From: [REDACTED]
Sent: [REDACTED]
To: Sian Eggington
Subject: FG/146/20/HH
Attachments: We sent you safe versions of your files; 5 South Drive FG_146_20_HH_form_1_cil_additional_information.pdf; 20210 SK104A location and block plan as existing.pdf

Further to your letter of the 16th November 2020, consider the following

5 South Drive, Ferring Location & block plan as existing

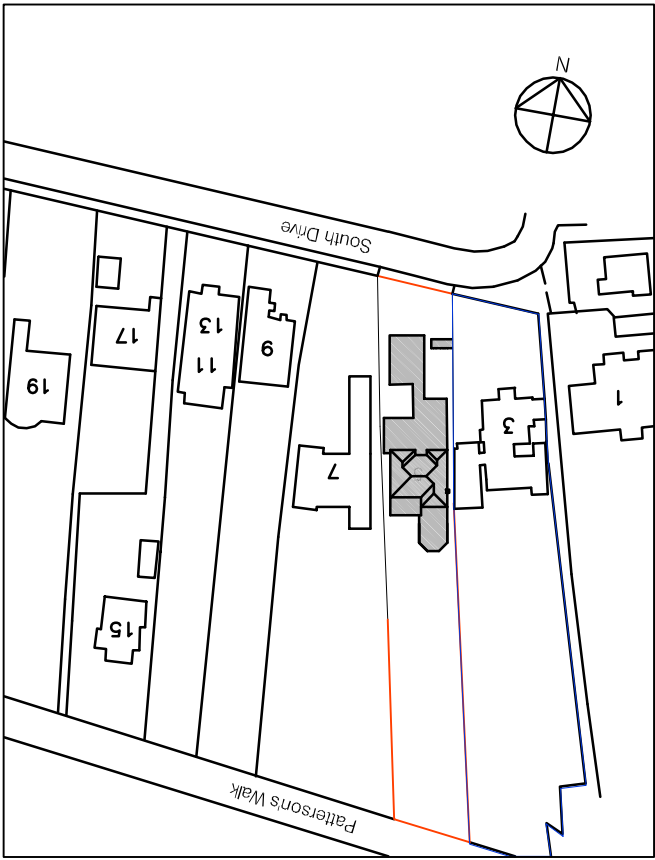
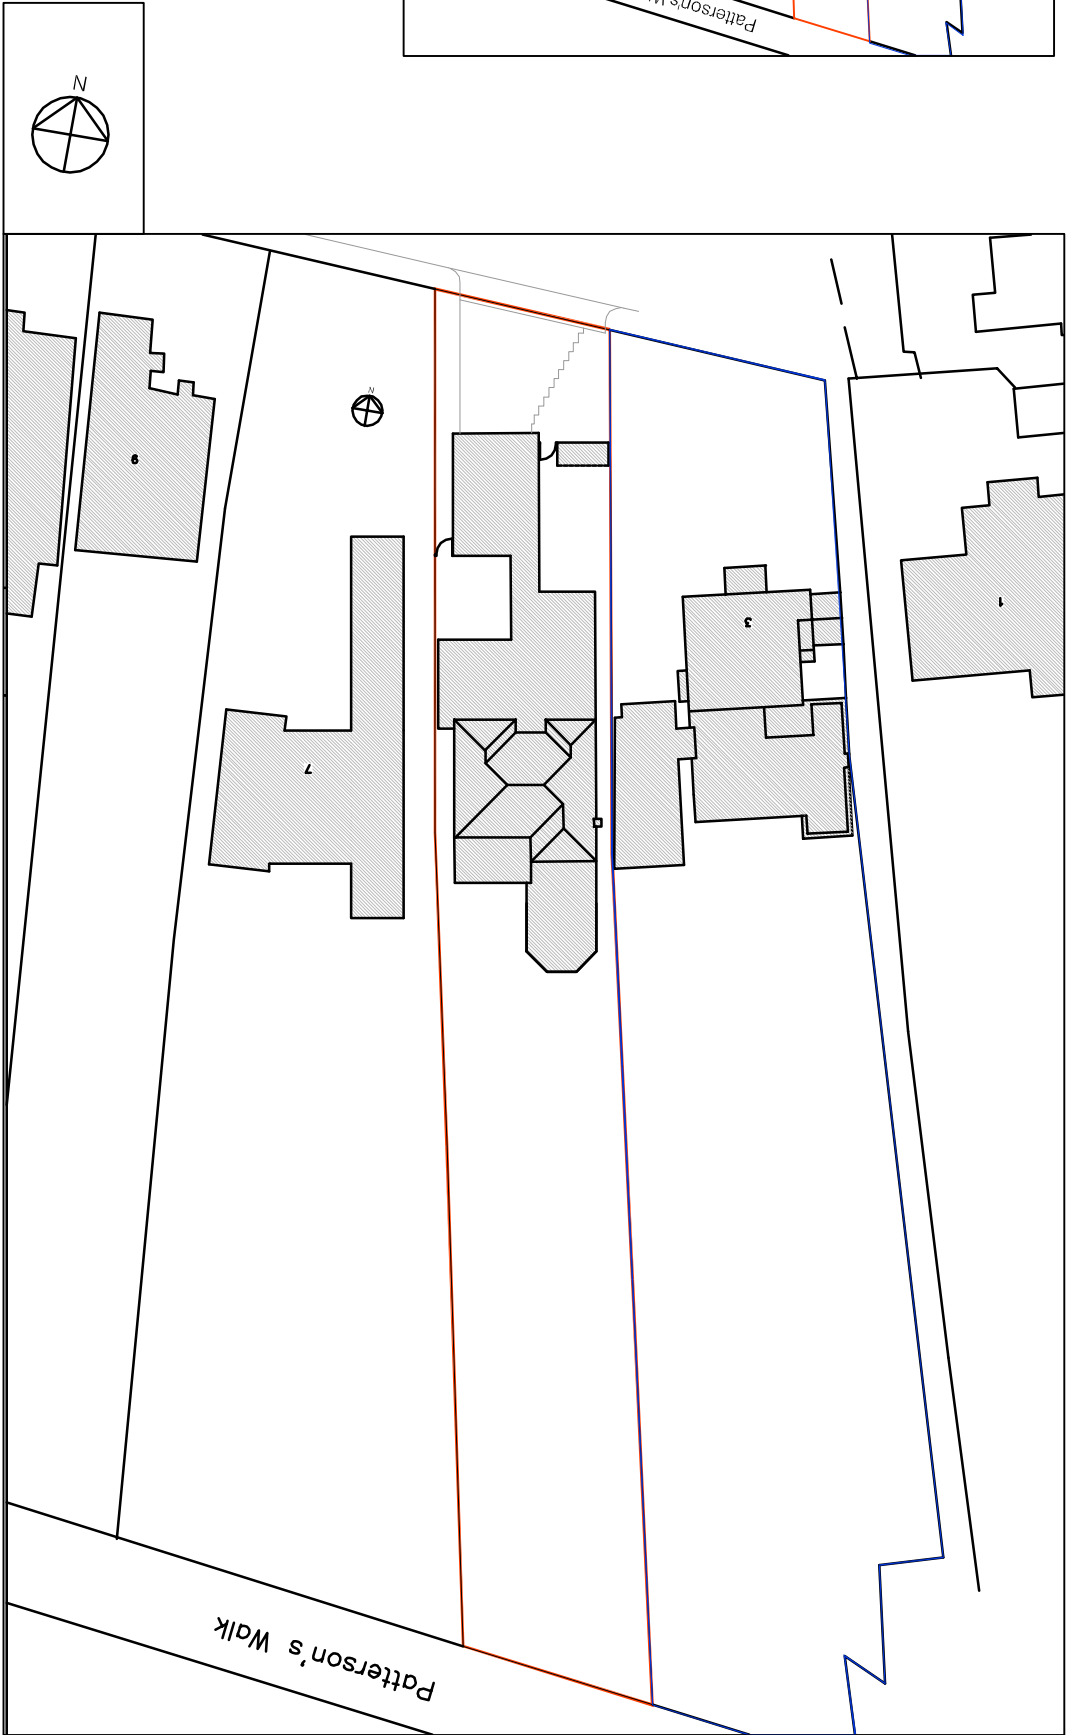
1. CIL Information Form Attached
2. The location plan. We have revised the red line to the boundary which on our system borders the whole site. (attached SK 104A)
